**RE: Sage Ranch Subdivision
Grading and Drainage Plan
Stamp Date: 01/19/18
Hydrology File: M09D025A**

Based upon the information provided in your submittal received 01/26/2018, the Grading and Drainage Plan **is not** approved for action by the DRB on the Preliminary Plat. The following comments need to be addressed for approval of the above referenced project:

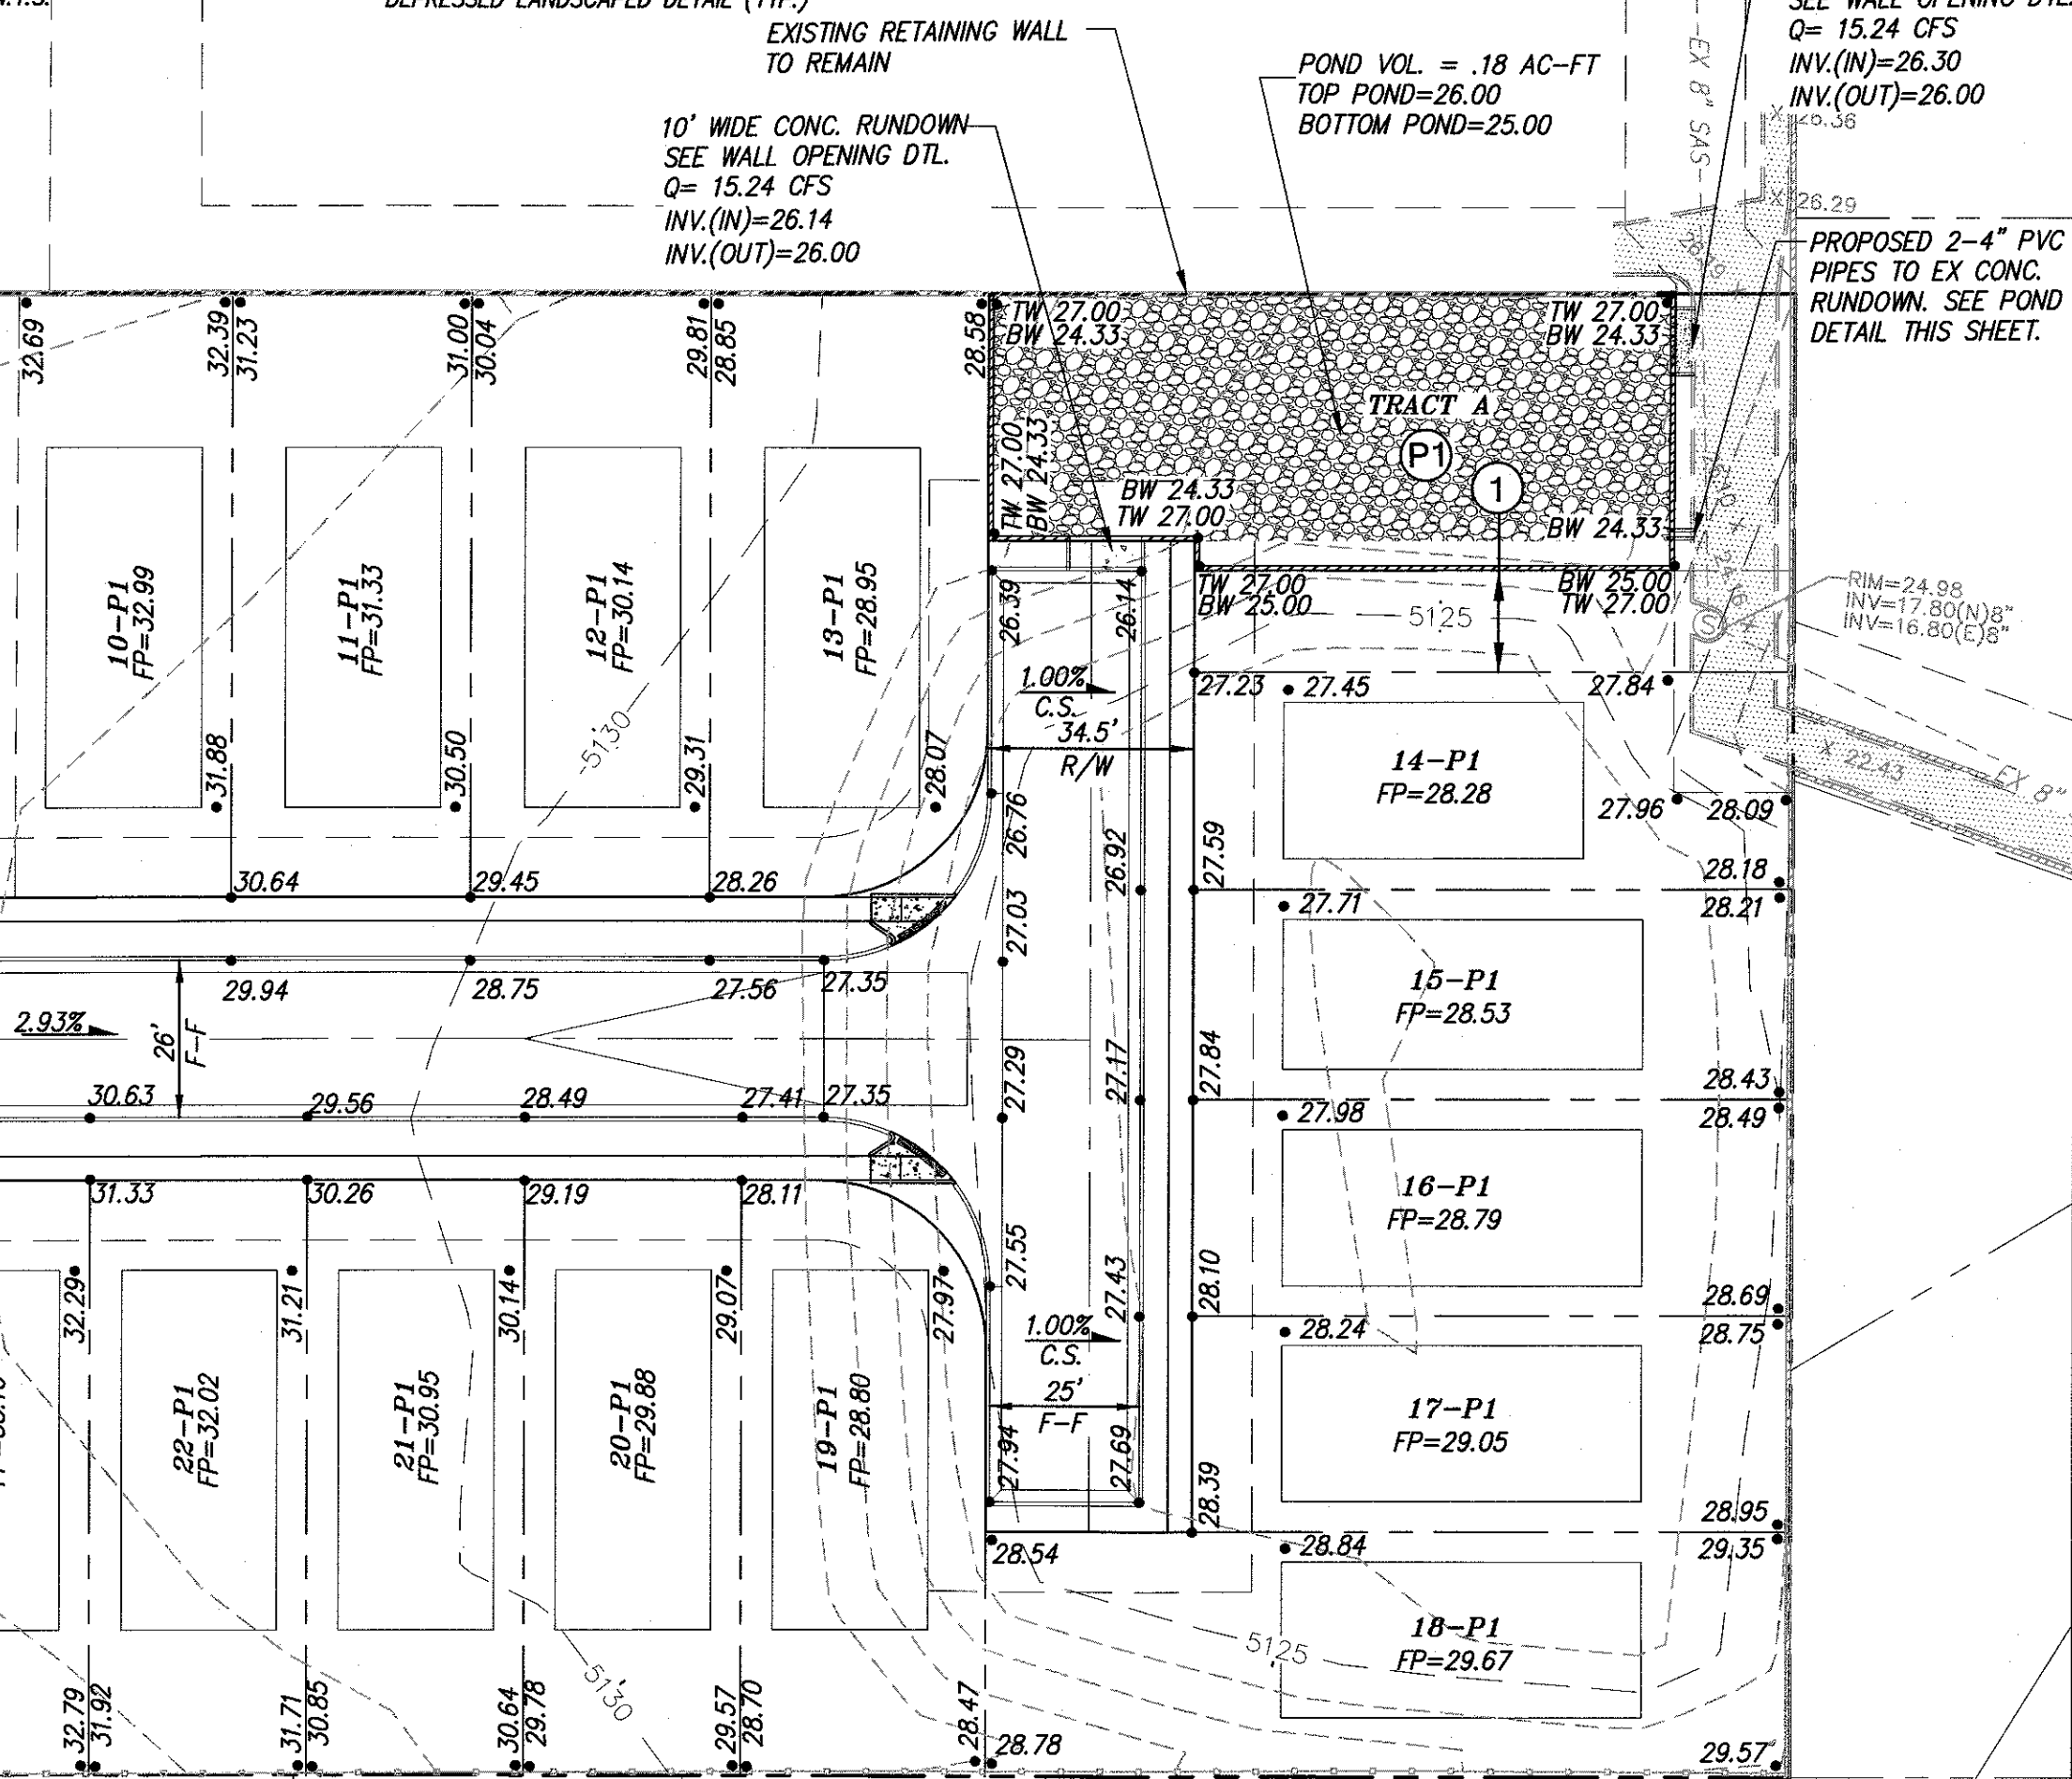
1. The Sage Marketplace Drainage Report dated September 2005 by Tierra West, stated the commercial part of the site will discharge to a detention pond which will discharge at a rate of 8.57 cfs. It further states that the total discharge for both the commercial and residential sites will be 17.49 cfs which is less than the allowed 18.4 cfs in the Sun Sage Hills Subdivision Drainage Report dated September 1996. Therefore the residential is only allowed 8.92 cfs according to the 2005 drainage report. The above project states that the residential is free discharge of 15.24 cfs. This is much higher than the allowable 8.92 cfs. Therefore a detention pond will be needed to hold the volume from the 6.32 cfs difference. Lot 14-P1 will have to be changed to a detention pond tract.

2. Since a detention pond is needed, required first flush volume can be handled in the new detention pond instead of separated.
3. Please add Grading and Drainage Plan to the title of this sheet.
